From: Bruce Taunton
Sent: 20 November 2009 09:51
To: Planning.Responses
Subject: RE: Planning Consultation on: K/22/09/

APPLICATION NO: K/22/09/

Registered: 23-OCT-09
Site Address: Chelsfield 53 Coastal Road East Preston BN16 1SN

Description of Works: Construction of third floor extension with flat roof, first floor balcony access to sun deck, garage extension, additional driveway parking & boundary wall erected to front of property

Proposed Boundary Wall - including proposed front elevation
1:50

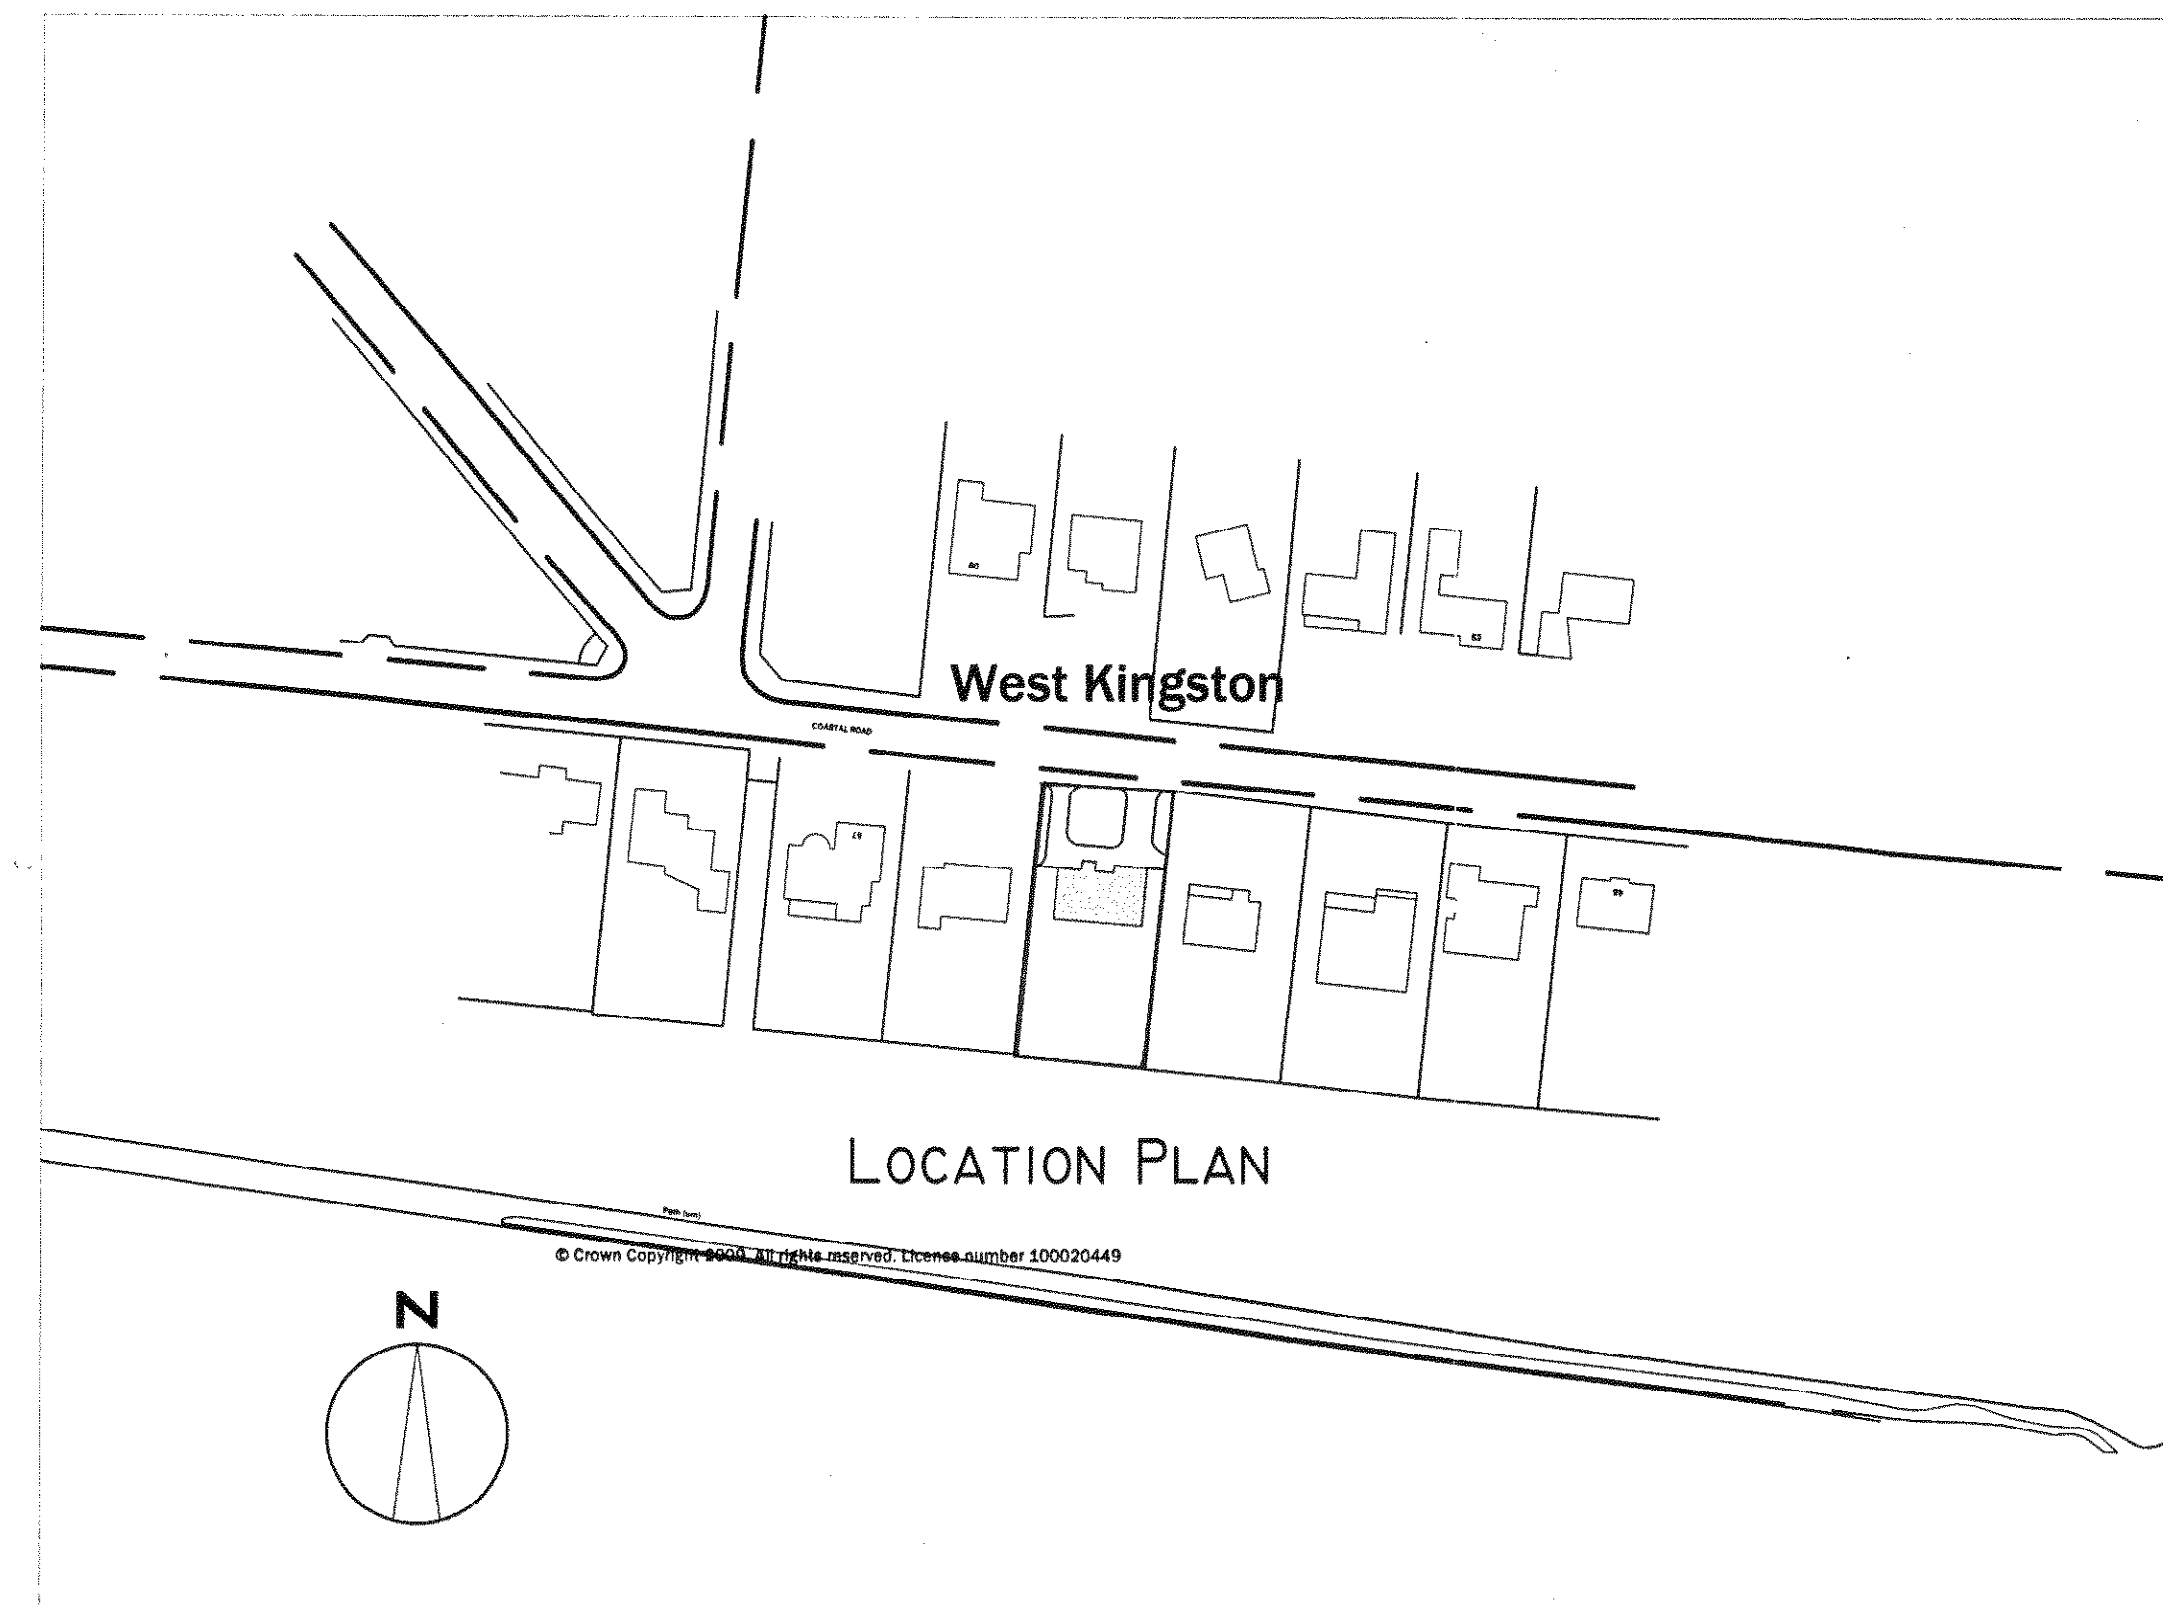
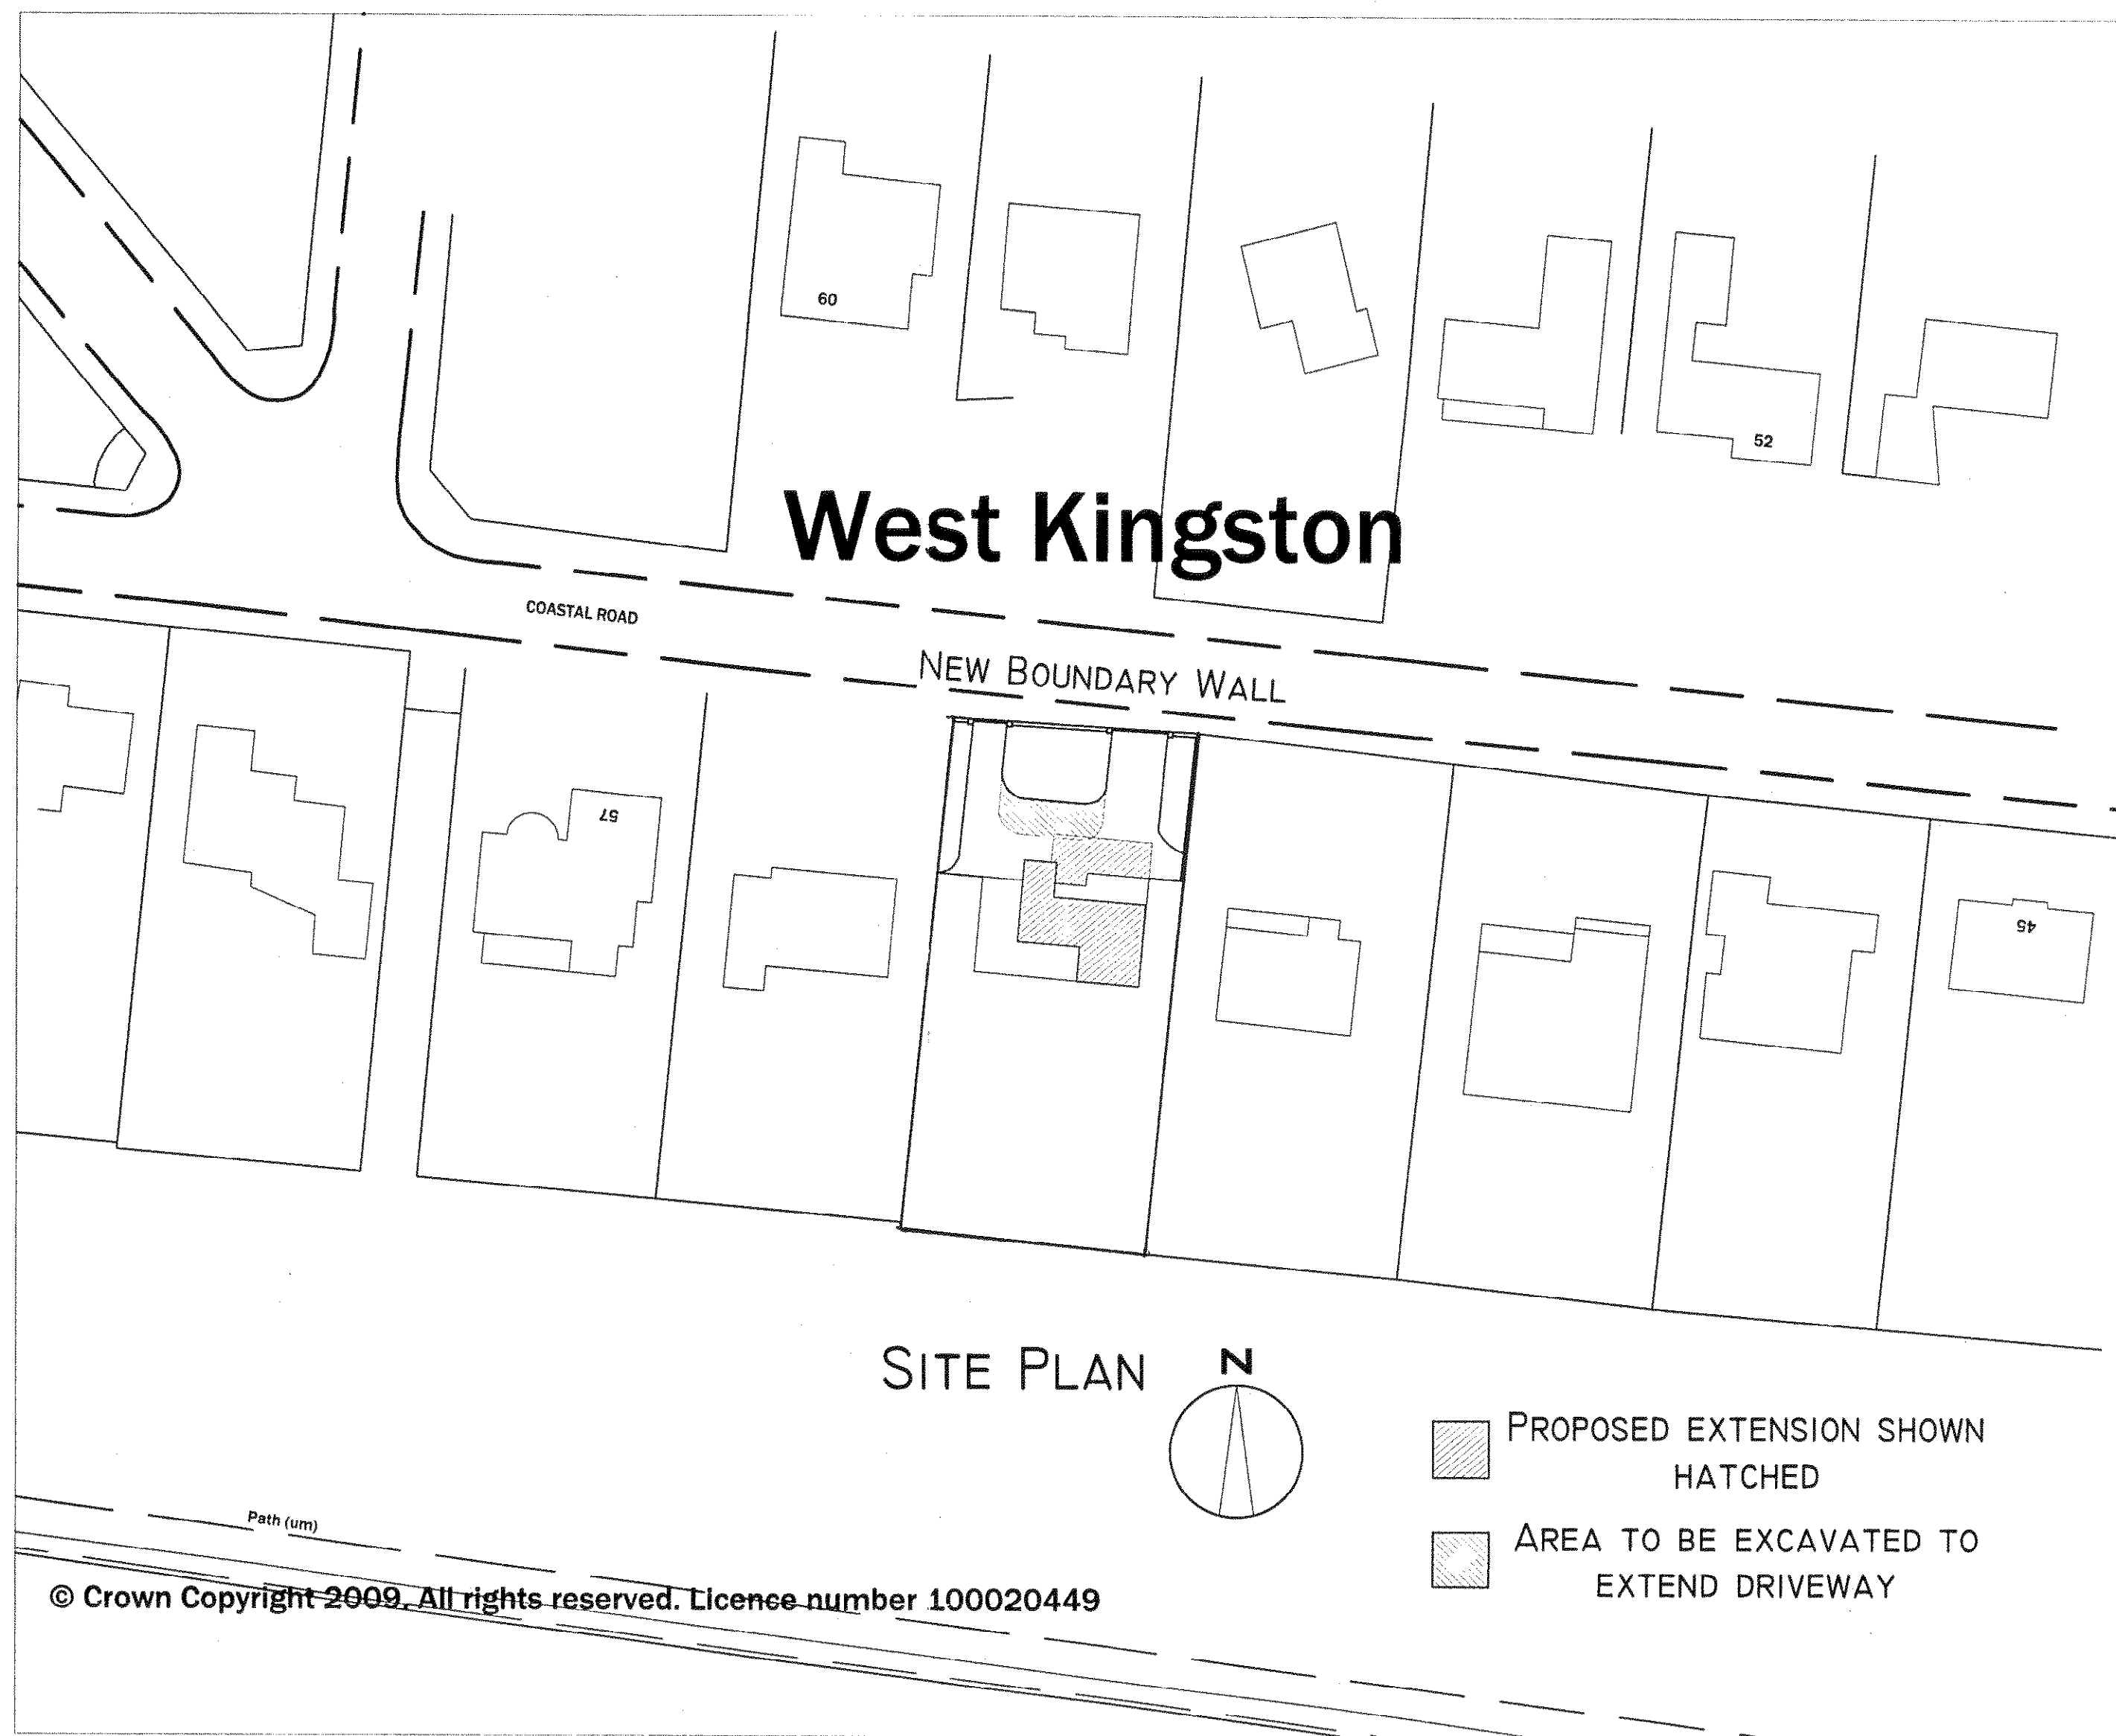
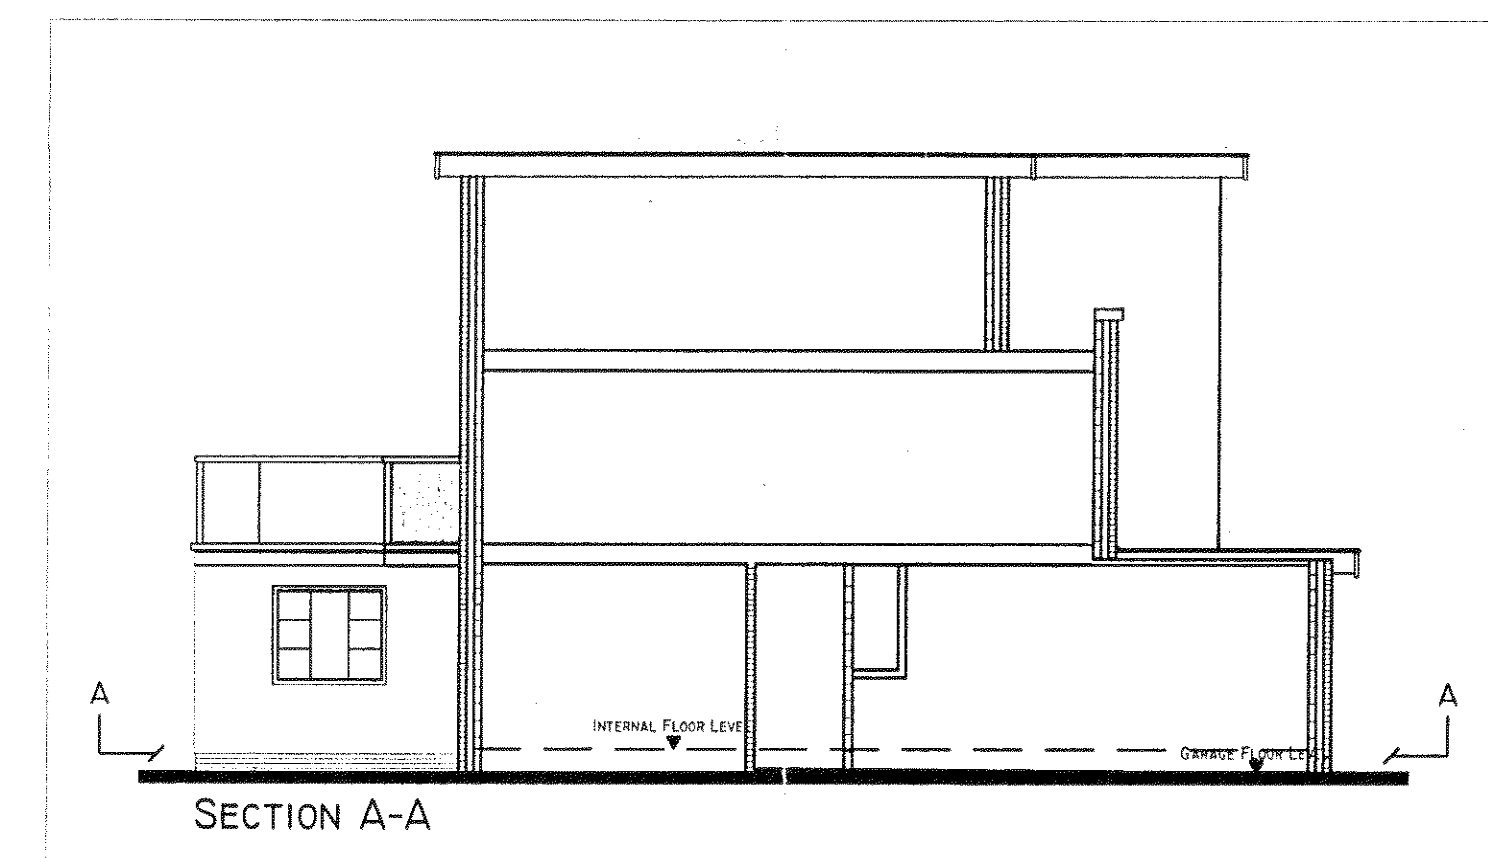
Depending upon the boundary wall thickness and design, there may be a need for an extra pier at the middle of the central portion of the proposed boundary wall. All other structural queries will be covered under the Building Regulations and we therefore have no other comments.
